30/11/20

15 Hazel Avenue
Withernsea
East Riding of Yorkshire
HU19 2PQ.

As regarding our telephone conversation on 26-11-'20 re new build on carpark, here are my concerns in writing as requested.

DRAWING No.  
ELDON 08 2020 1D  
SCALE  
1:50 @ A1

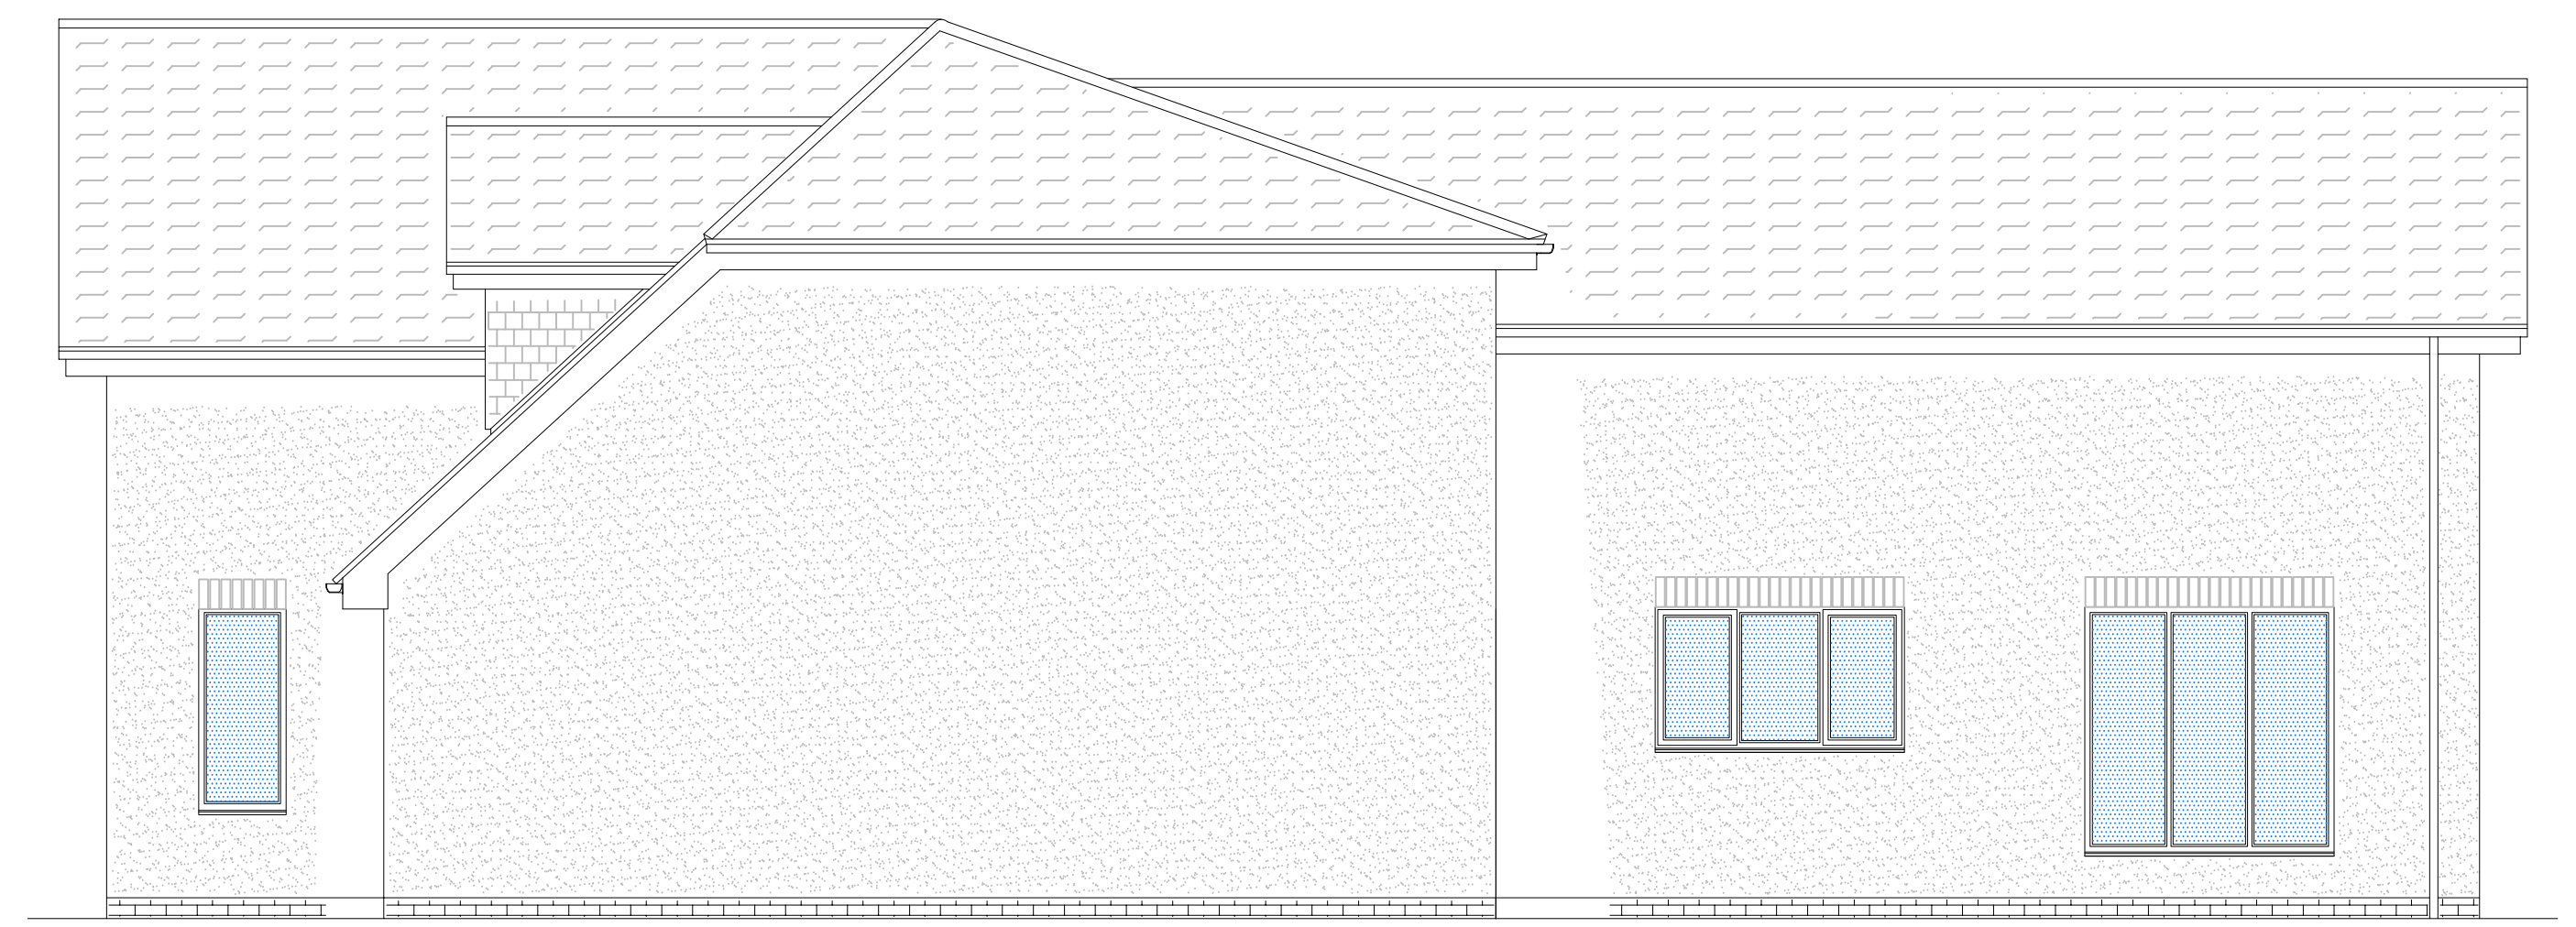
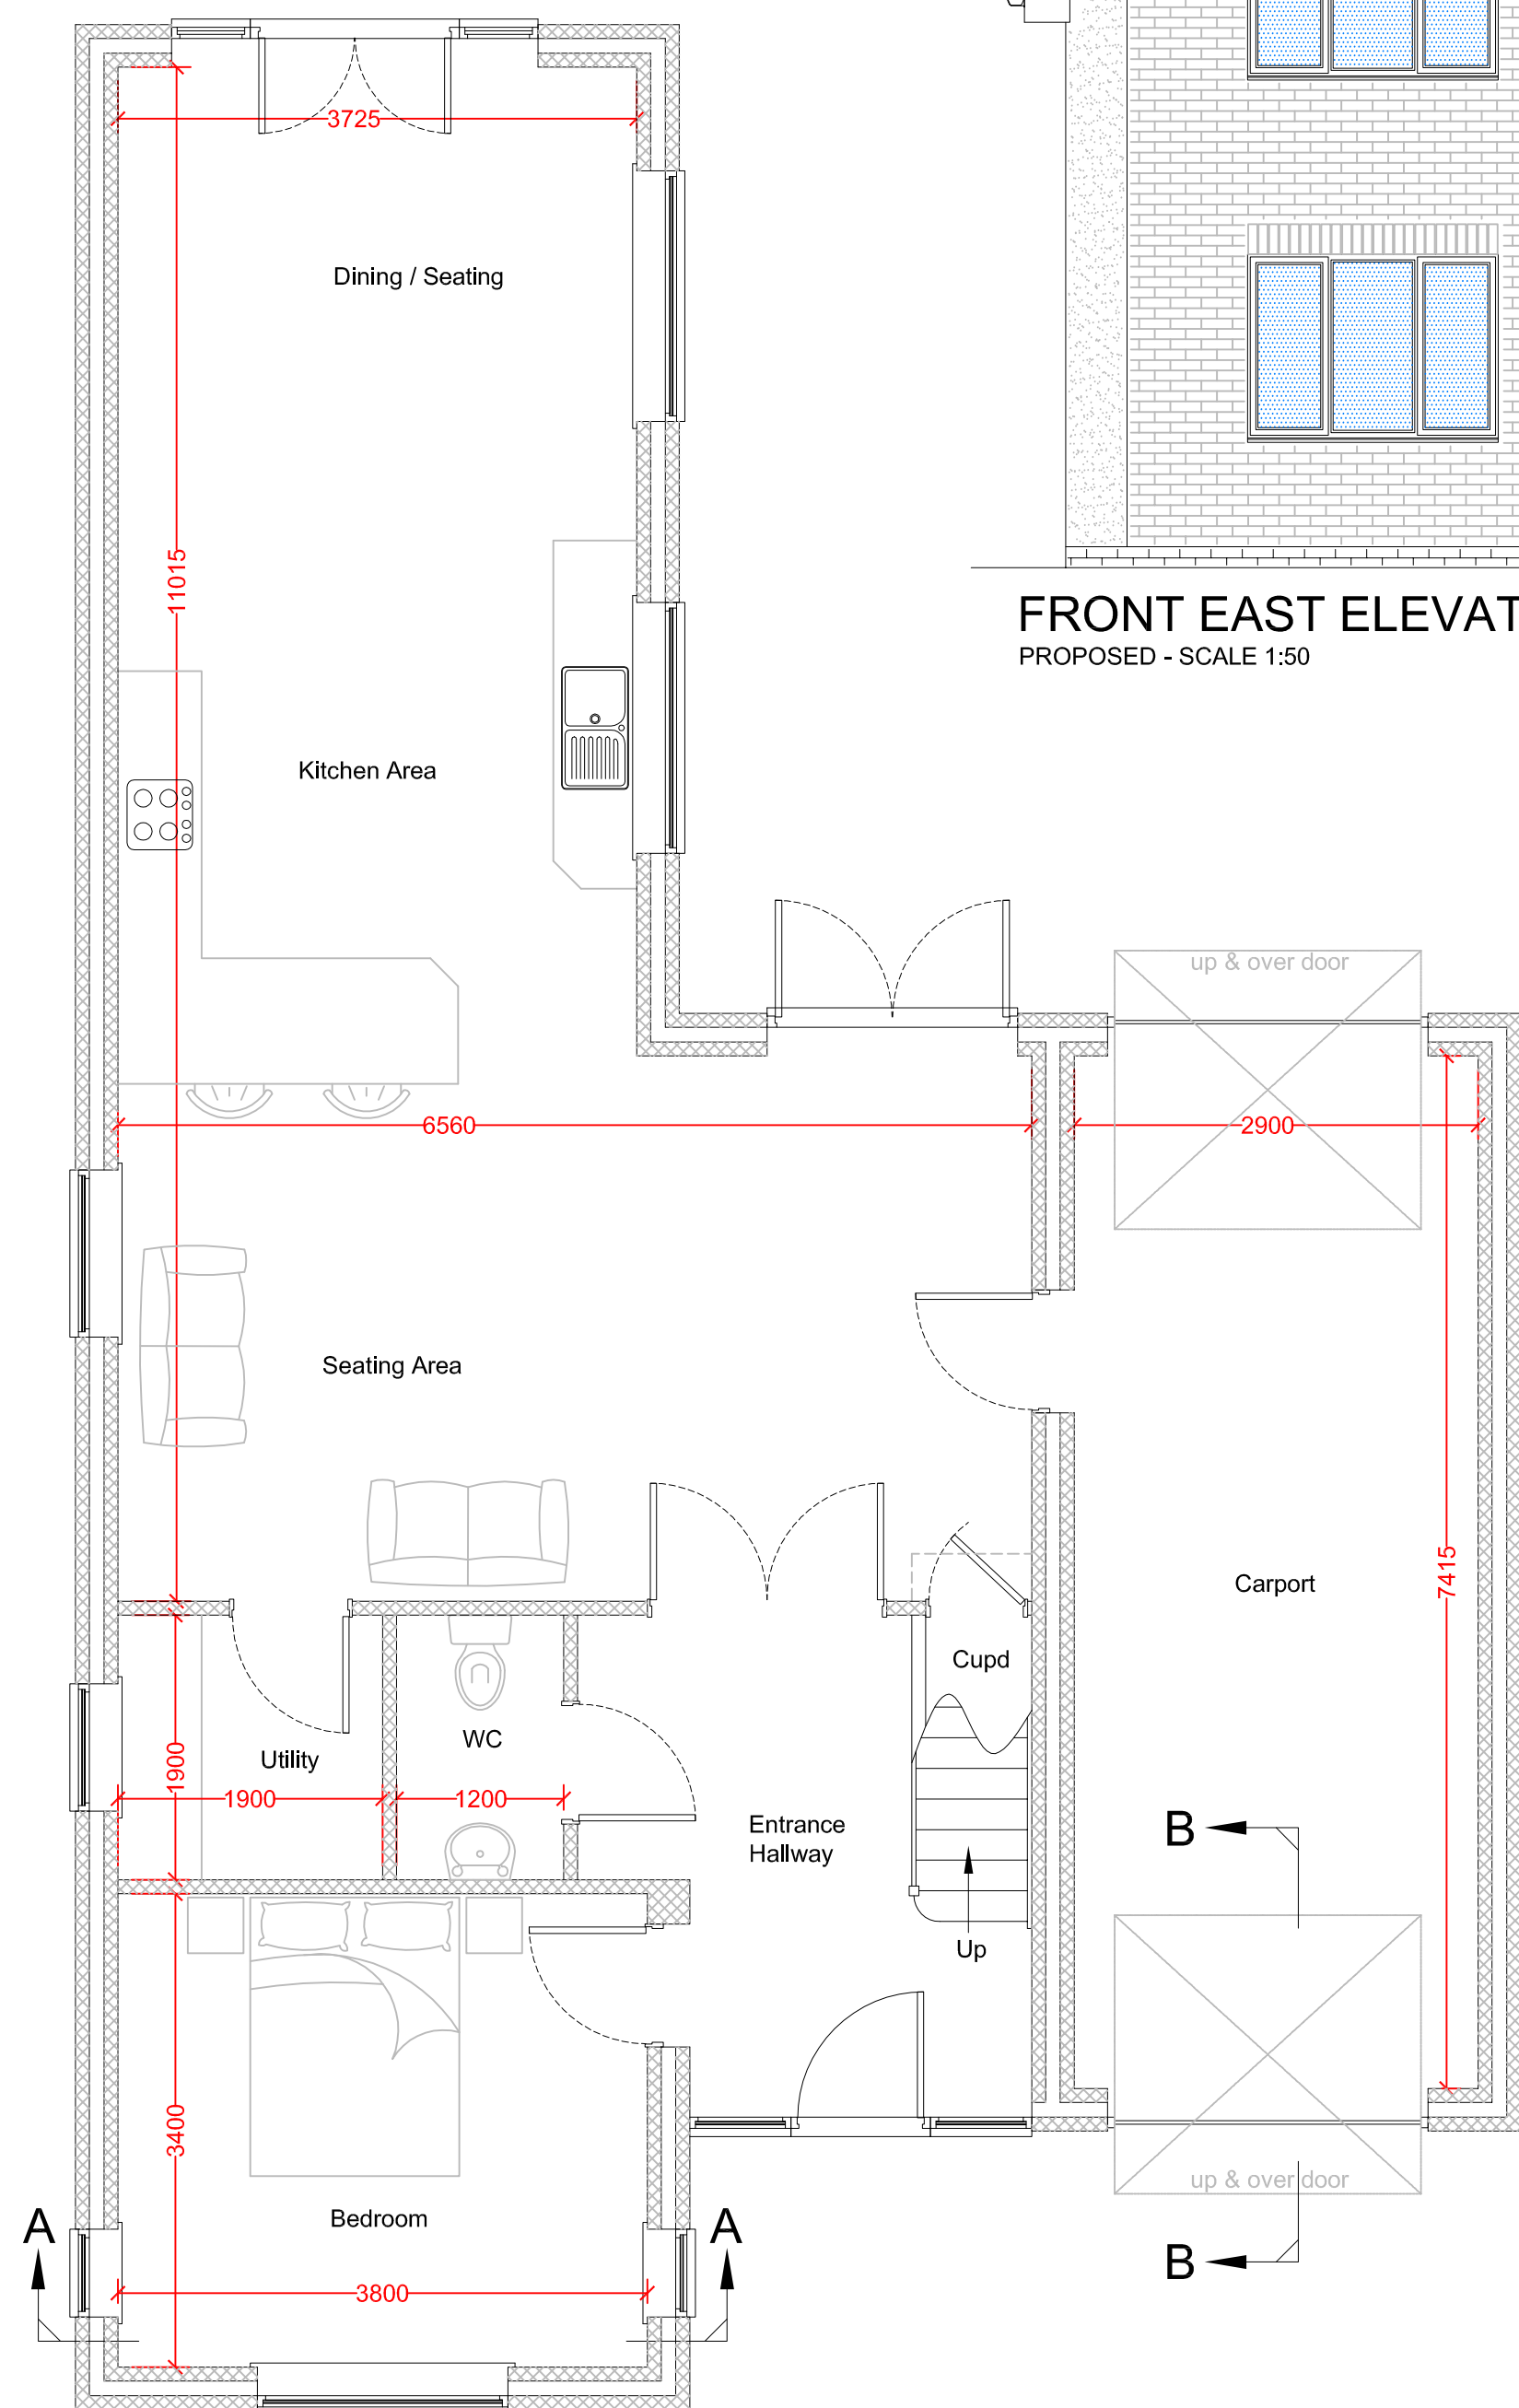
- ① I was assured by yourself in Nov 2019 that any proposed new build would be a bungalow no higher than No 13 to be in keeping with other properties. Now I see from the submitted plans that a two storey dwelling is being proposed.
- ② A four bedroomed house is being proposed. Two story build which is a house not a bungalow. I am very disappointed that plans are being submitted for such a build.
- ③ After our conversation I am
